Comments from [REDACTED]

My sympathy goes out to the Planning Department for having to deal with what I believe is a retrospective planning application because what has been built is not in accordance with that granted under 6/2019/1813/FULL in respect of the machinery store plan PL01D dated 30th August 2019 showing four roof lights in each roof elevation. This decision was taken in consultation with the historic building and conservation advice given by [REDACTED] particularly in respect of fenestration and following a major objection from the Parish Council.

JOB No.	2109
DWRG No	FLO 1
SCALE	1/100 @A1
DATE	JULY 2019
DRAWN	PH
CLIENT

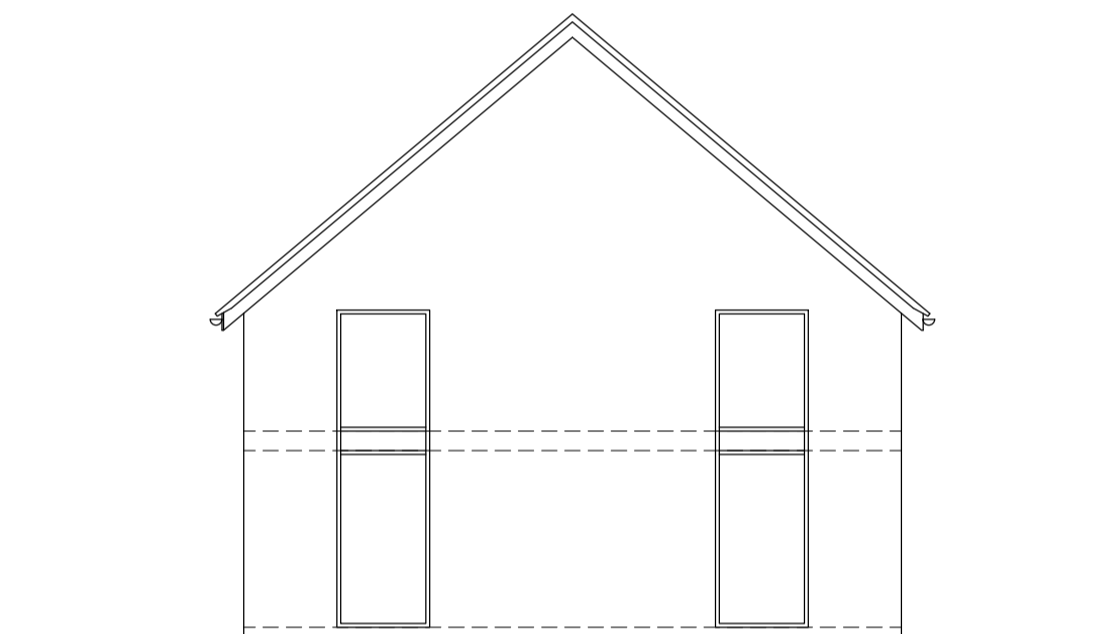
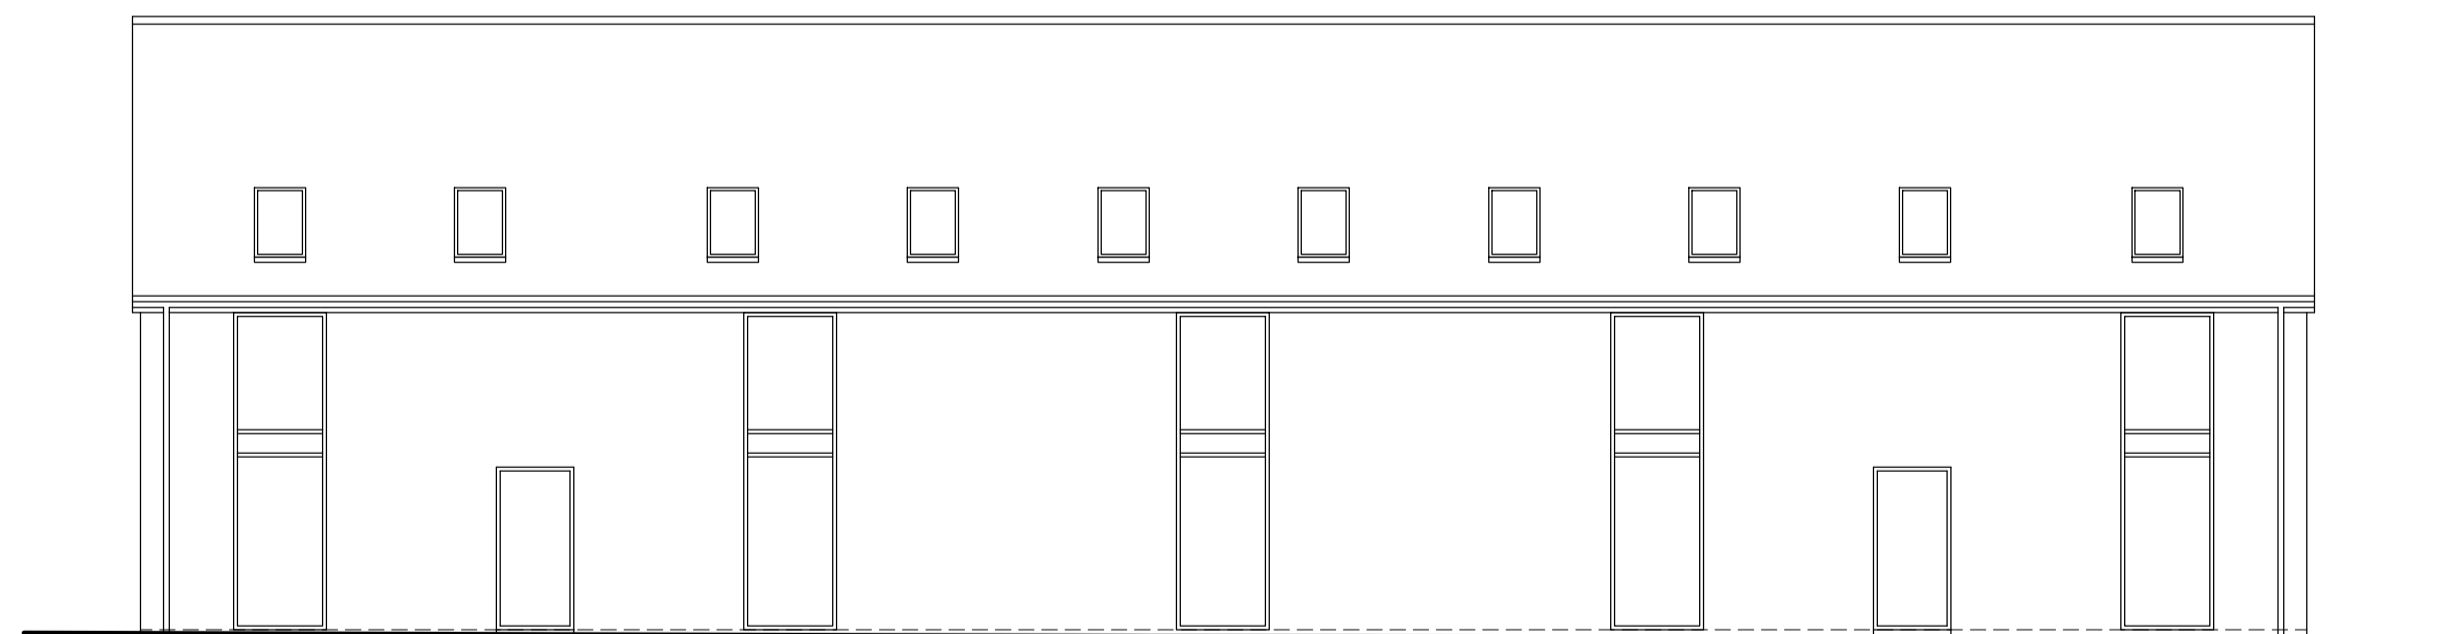
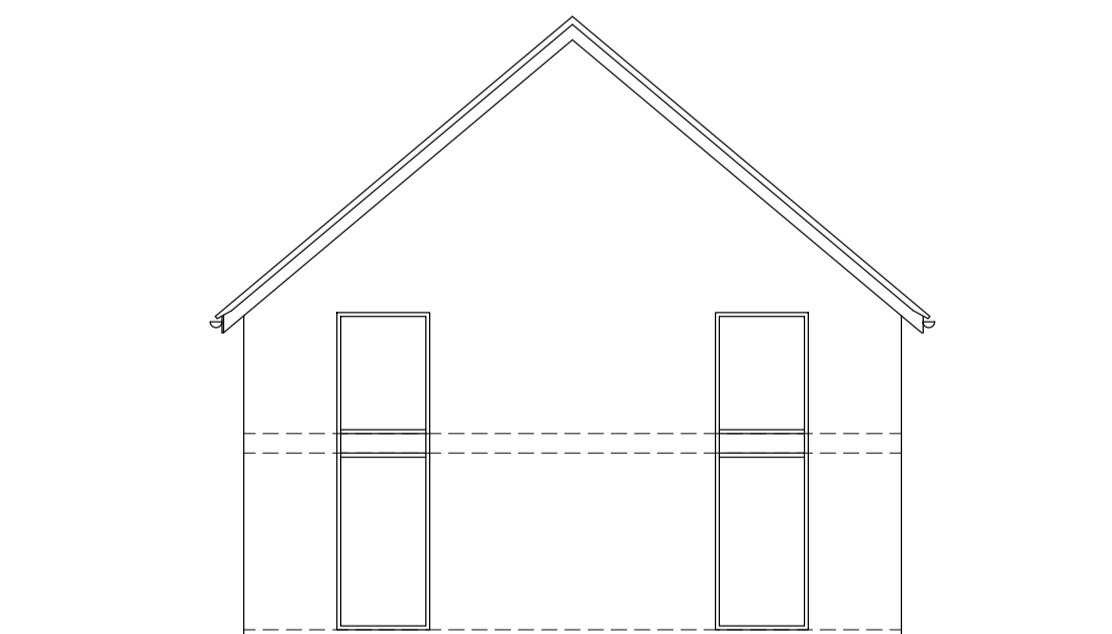
This new application shows eight roof lights on the roof elevation facing the old barn PL10E and four on the field elevation although it includes a superseded plan showing ten roof lights on each roof elevation dated June 2019 which had originally accompanied the earlier application but which was again superseded.
